February 15, 2023

**Re: XRANM Jefferson Office at 5800 Jefferson St. NE
Erosion and Sediment Control Plan
Engineer's Stamp Date 12/7/2021 (E17E011B)**

Based upon the information provided in your submittal received on 2/7/2023, the above referenced ESC Plan is conditionally approved to be included in the SWPPP and Building Permit Plans provided that the following comments are addressed.

EROSION AND SEDIMENT CONTROL PLAN

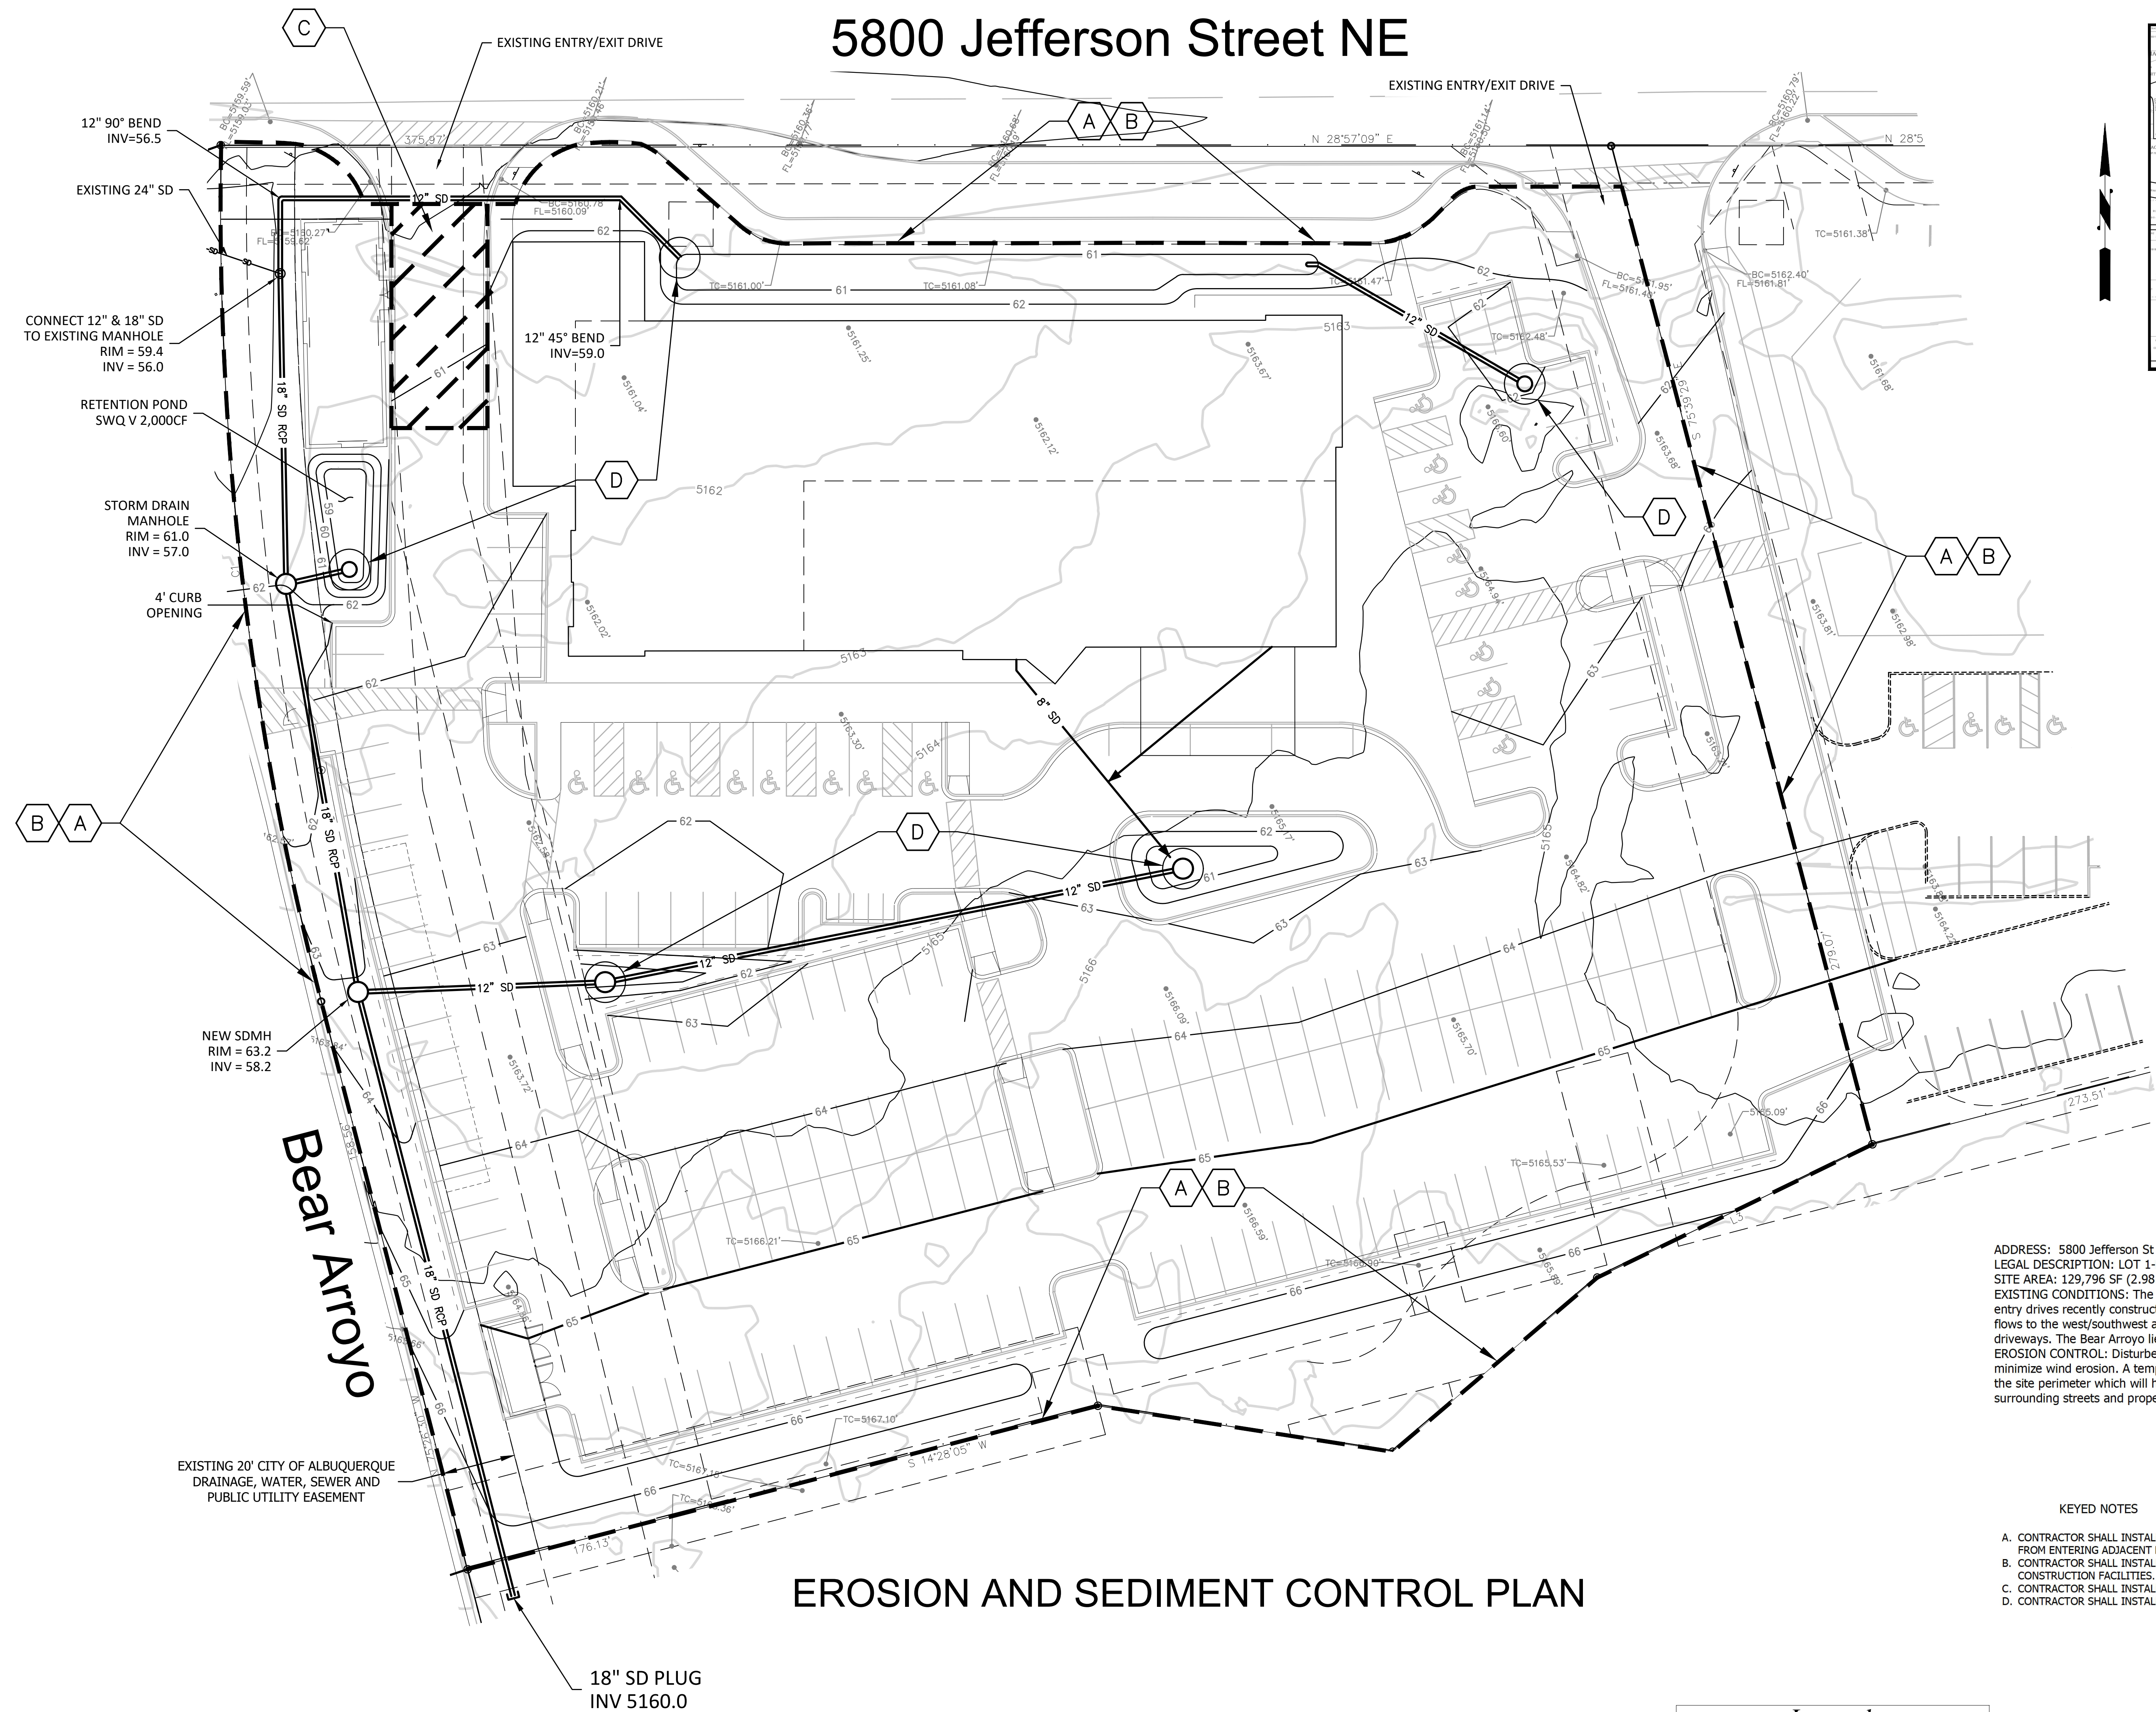
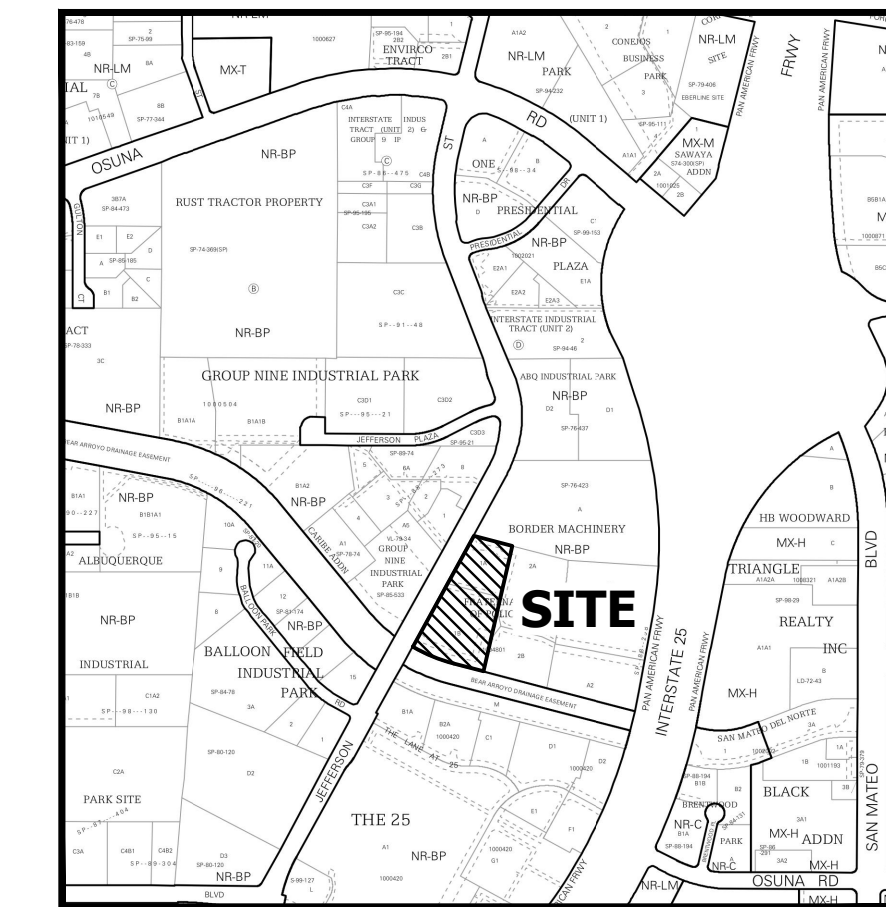
1. The Site Plan PR-2021-005746 and the plat filed 11/24/2021 of lots 1-A-1 and 1-B-1 is a 4.65 acre "Common Plan of Development or Sale." The main construction is occurring on lot 1-B-1, but construction support activities are occurring on lot 1-A-1, so the ESC Plan must be revised to include lot 1-A-1 including accurate locations of the limits of disturbance, silt fences, and specifications for stabilization.
